Design Renaissance

Cover Page

Letter of Intent

This Letter of Intent is being written because Randall & Gwyndena Petrick are proposing a land use project in El Paso County at 14195 Silverton Road. (see additional property information on Cover Page.)

**GUEST HOUSE FLOOR PLANS**

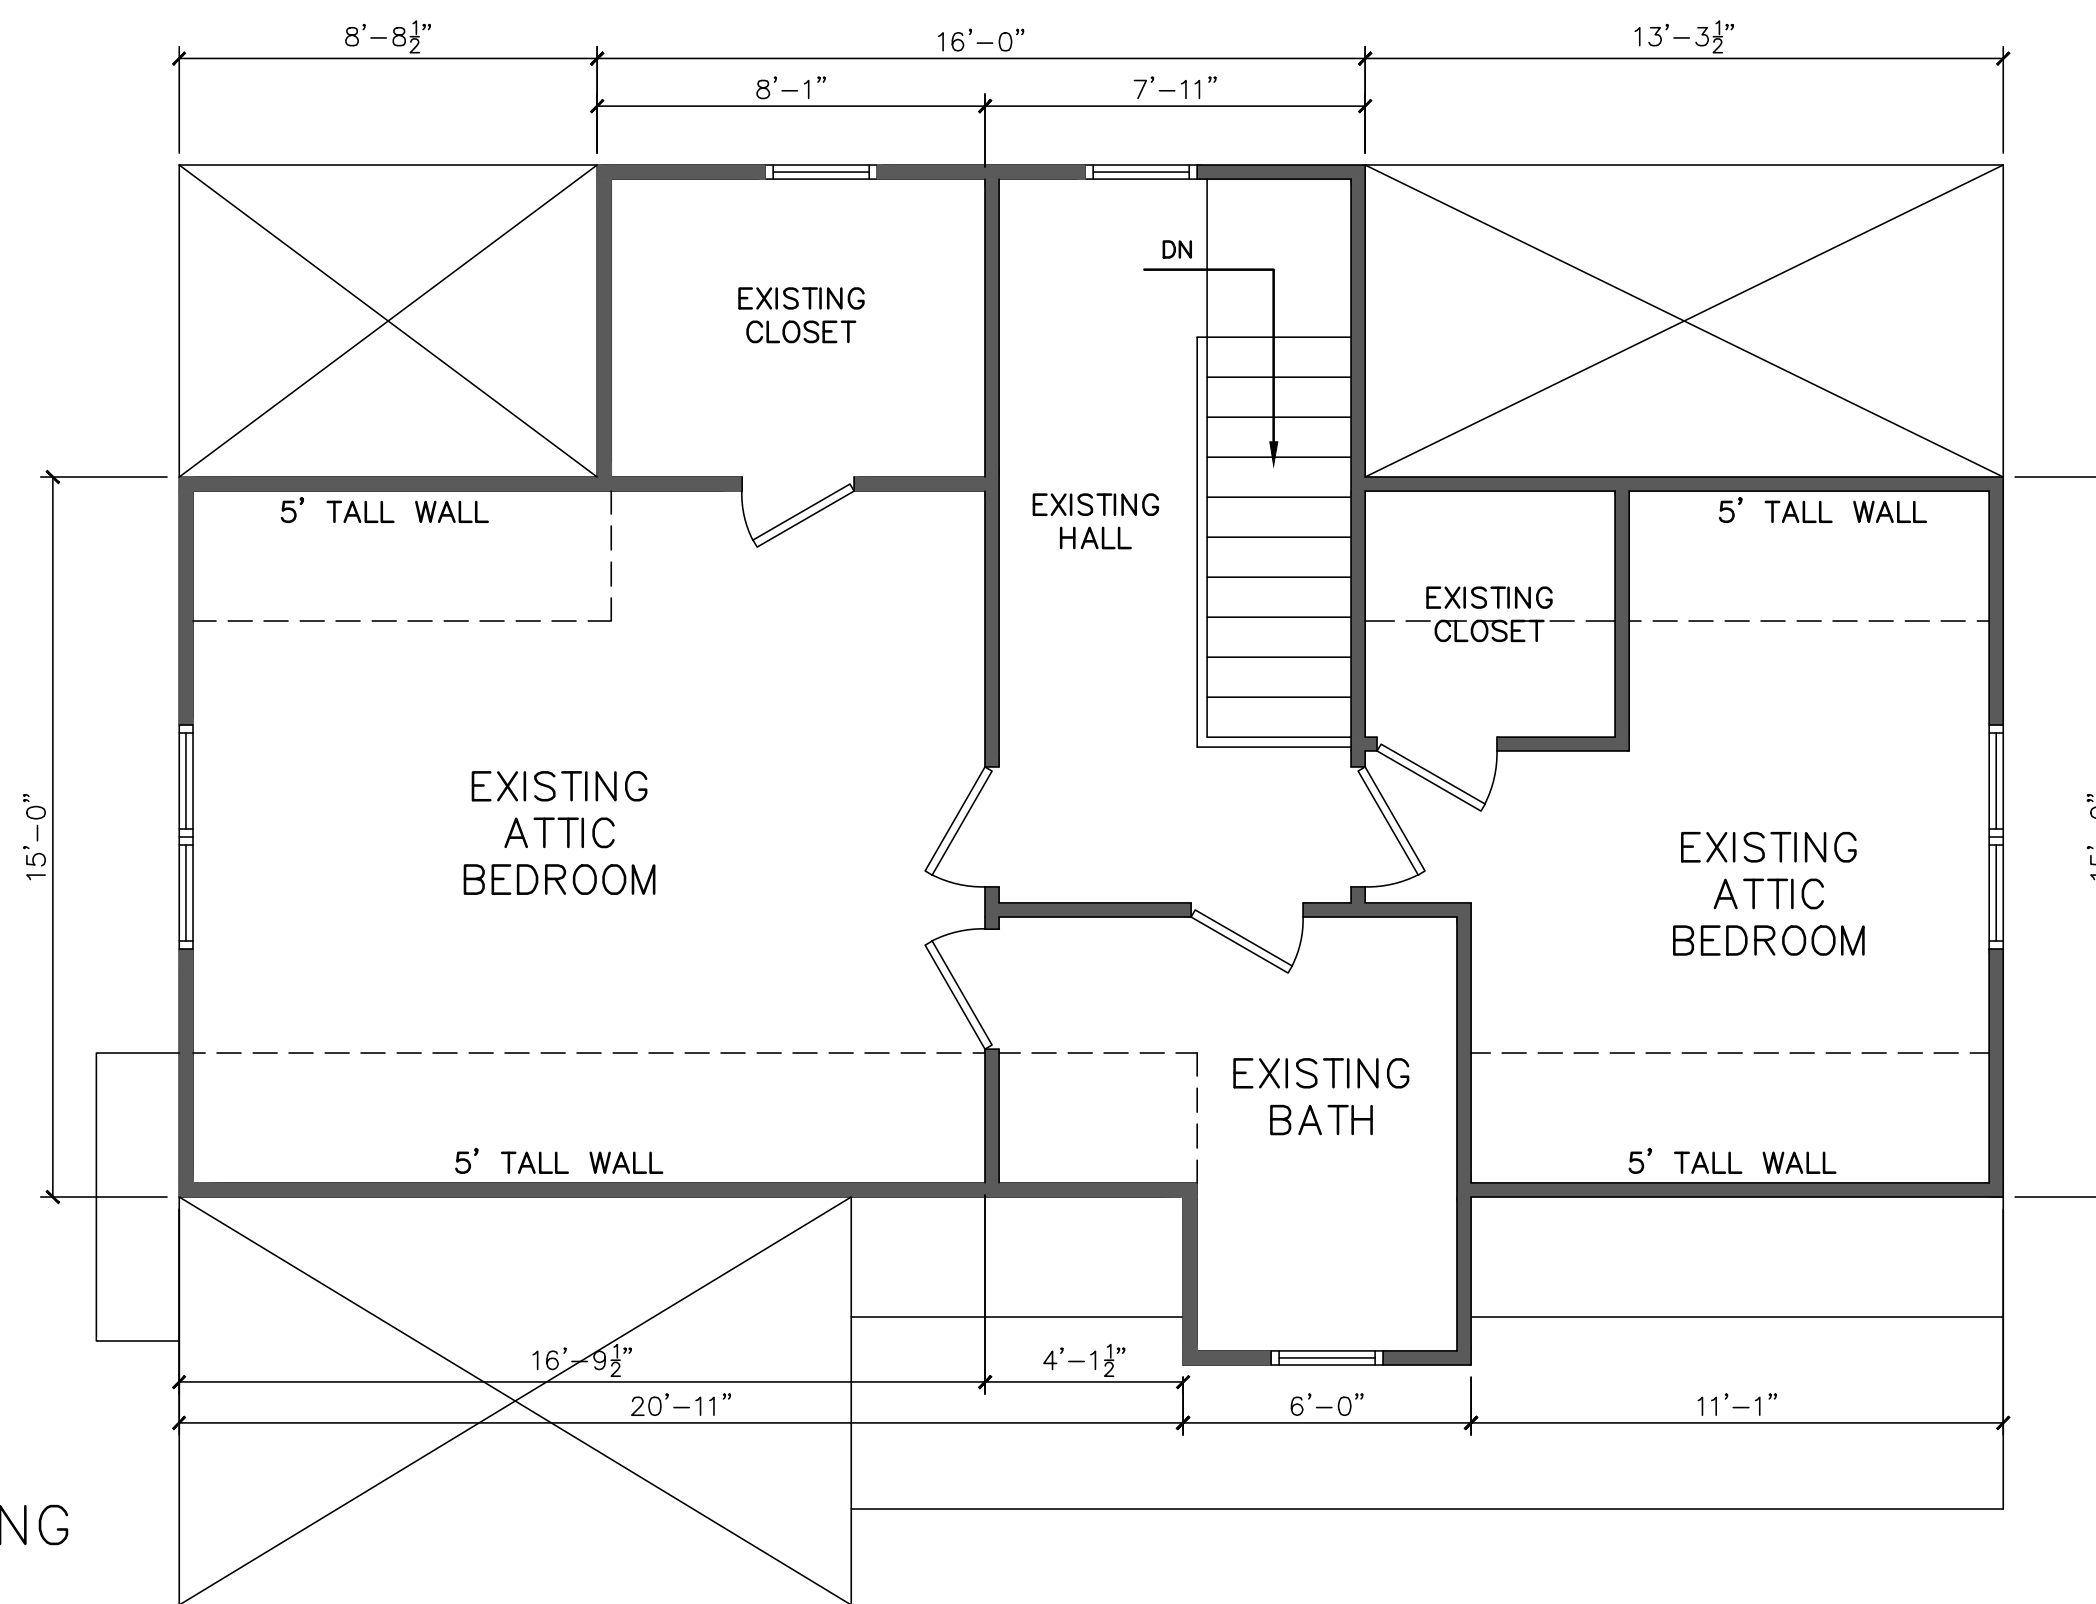
The assessor's website shows there is a basement. Floor plans will be required. What is the proposed use for the basement area?
